Application: 3/2020/1015

Application Site: Inglemead off Waddington Road, Clitheroe

Proposal: Erect 2 bed detached dwelling in rear garden

Drawing No. A209 Revision

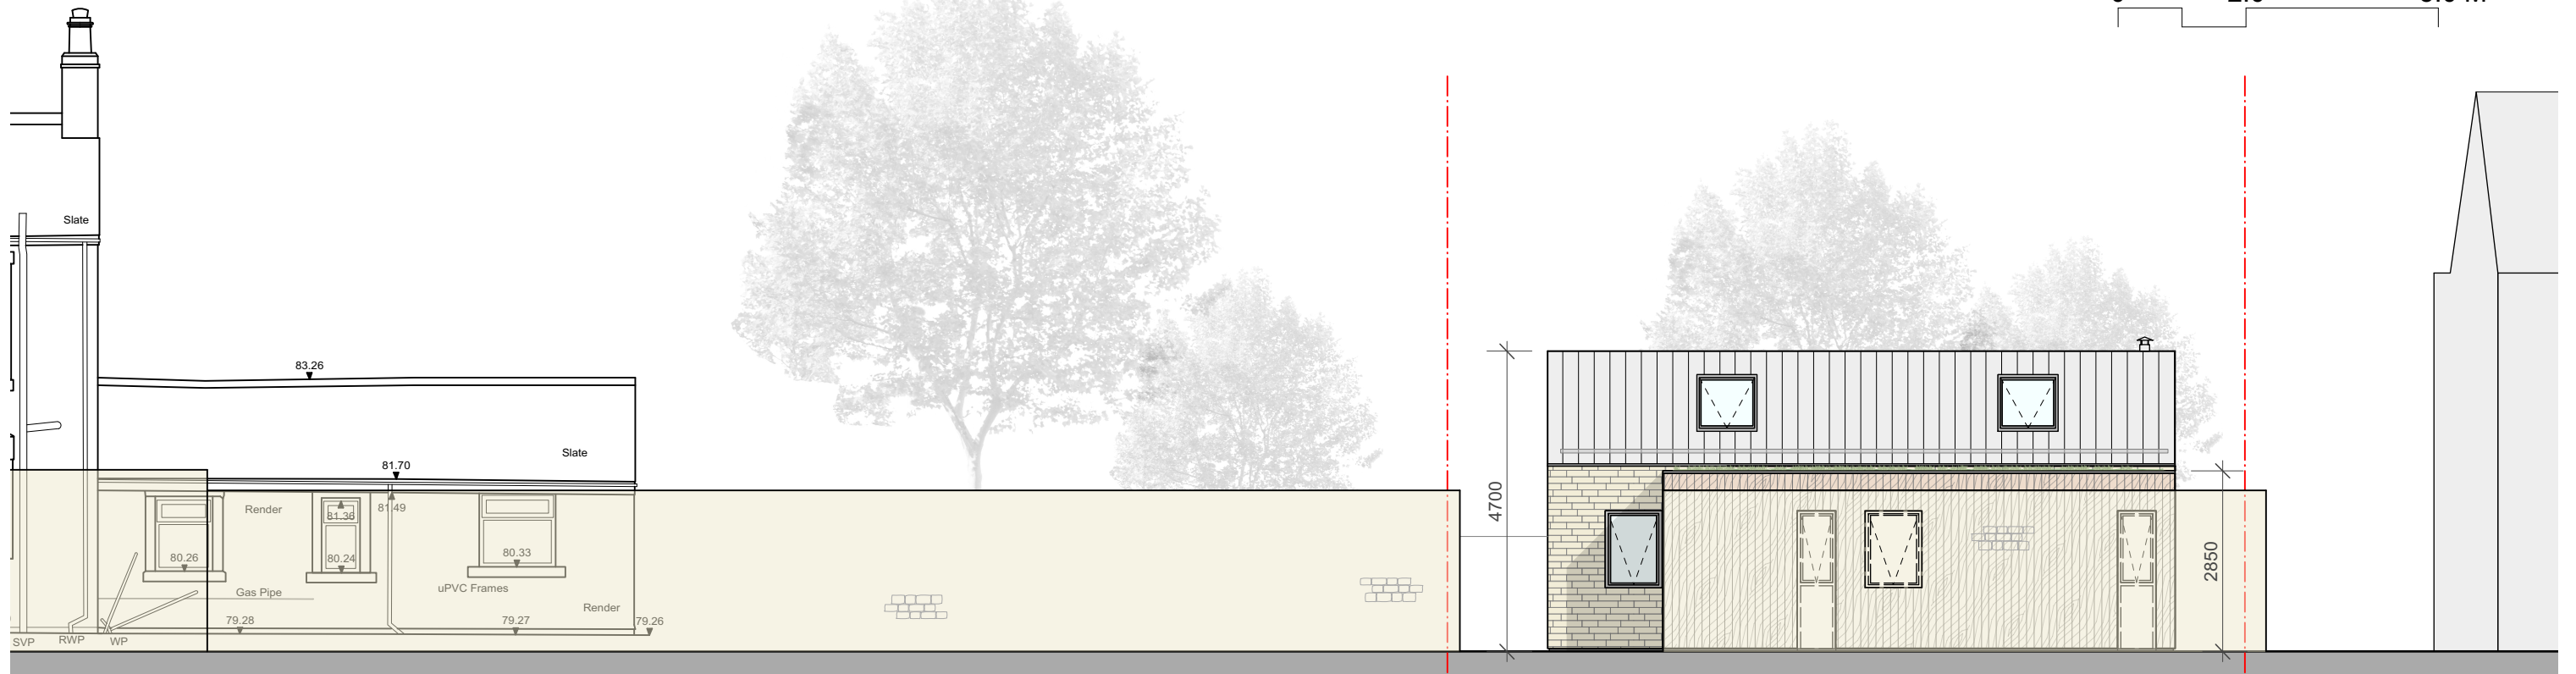
The elevation drawing submitted shows the retention of the high boundary wall on either side of the driveway. This would impair inter visibility between emerging vehicles and pedestrians which would not be acceptable. The applicant should therefore submit an amended plan with an access that would be compliant with the following requirements

45° visibility splays (residential driveway).

45° visibility splays shall be provided between the highway boundary and points on either side of the drive measured 3m back from the nearside edge of the footway. Nothing shall be erected, retained, planted and/or allowed to grow at or above a height of 0.9 metres above the nearside carriageway level which would obstruct the visibility splay. The visibility splays shall be maintained free of obstruction at all times thereafter for the lifetime of the development.

Reason: To protect pedestrians passing the drive and ensure adequate inter-visibility between drivers and pedestrian traffic, in the interests of highway safety.

Drawing No. A200 Revision

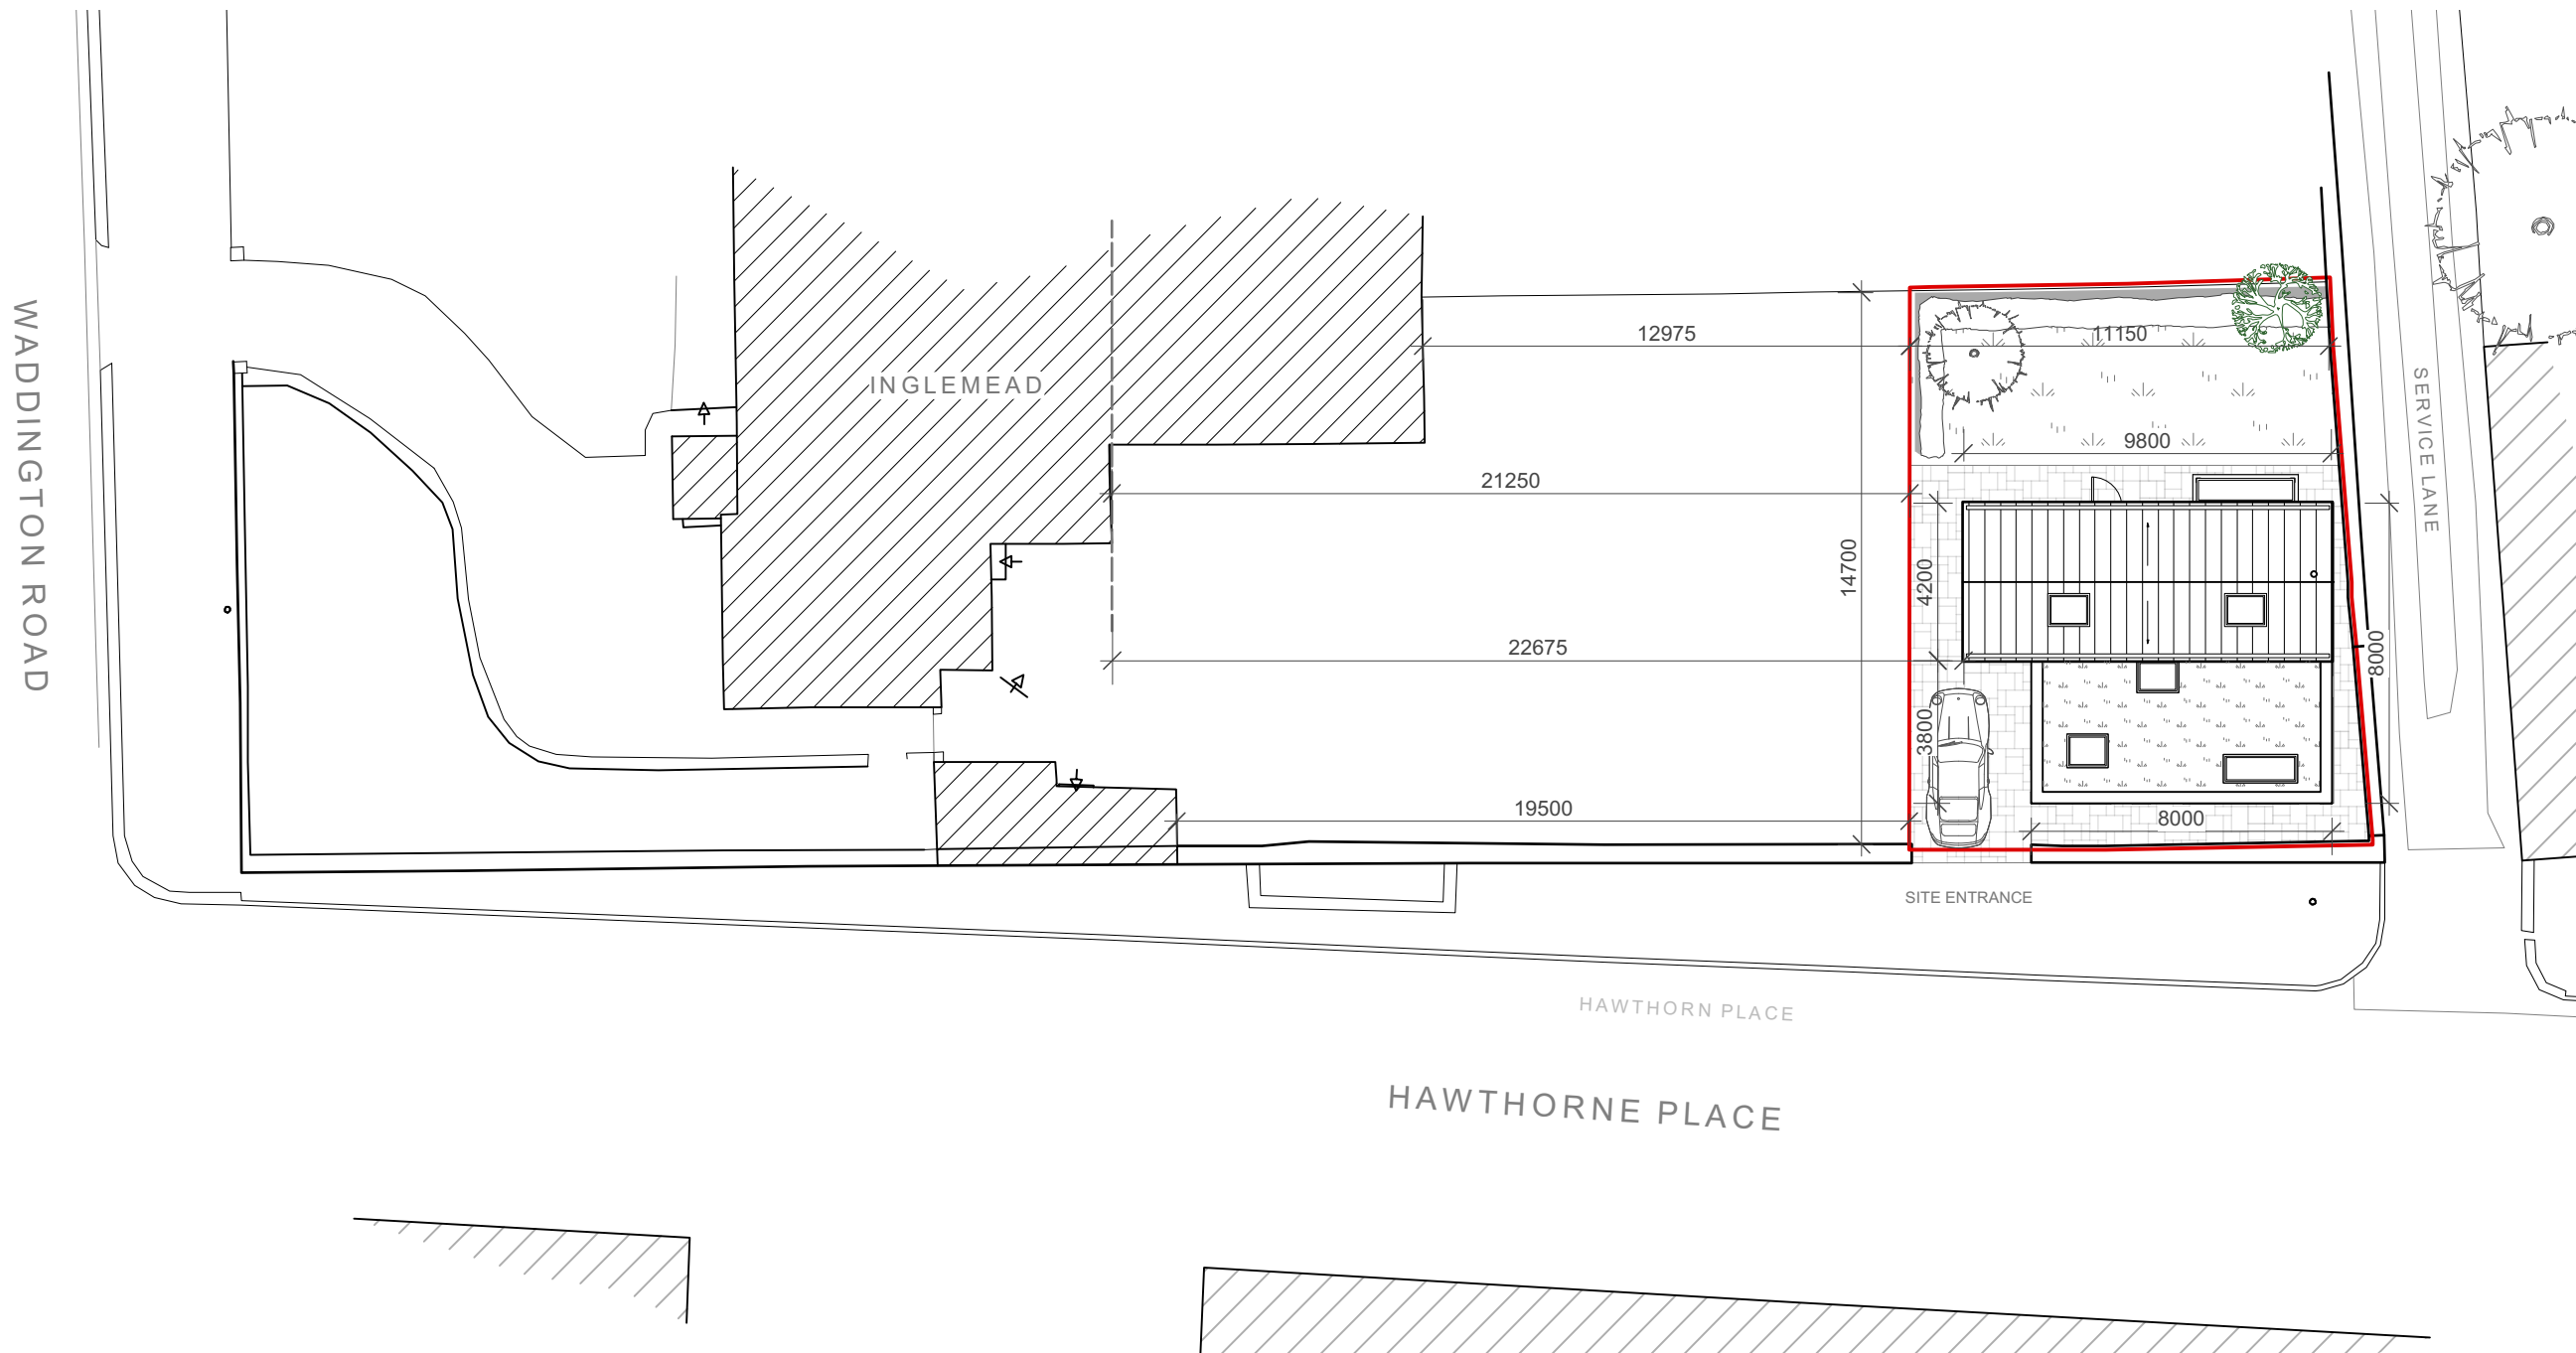
The proposal is for the erection of a 2 bed detached dwelling in the rear garden of Inglemead off Waddington with access to a single parking space taken from Hawthorn Place. Whilst a 2 bedroom property would usually require the provision of 2 off street parking spaces in this instance with the proximity of the proposed development close to Clitheroe Town centre and all the facilities that are available, the provision of a single parking space would be acceptable. However when considering the dimensions of the parking space, the length and width (approximate measurements 5m and 3m respectively) are considered inadequate. The length should be 5.5m – 6m to avoid the likelihood of a parked vehicle overhanging the footway. In respect of the width this should be a minimum of 3.2m but since the access to the property is directly adjacent to the parking space this may need to be increased to accommodate the potential needs of wheelchairs users / prams etc.

In complying with this it is noted that a section of the wall to be reduced will be under the ownership of a third party (Inglemead) and arrangements would be necessary to ensure that the height of this section of wall is not increased over the passage of time.

Finally a vehicle access crossing would be required and given the proximity of the site to the town centre a "H-bar " marking would be advised
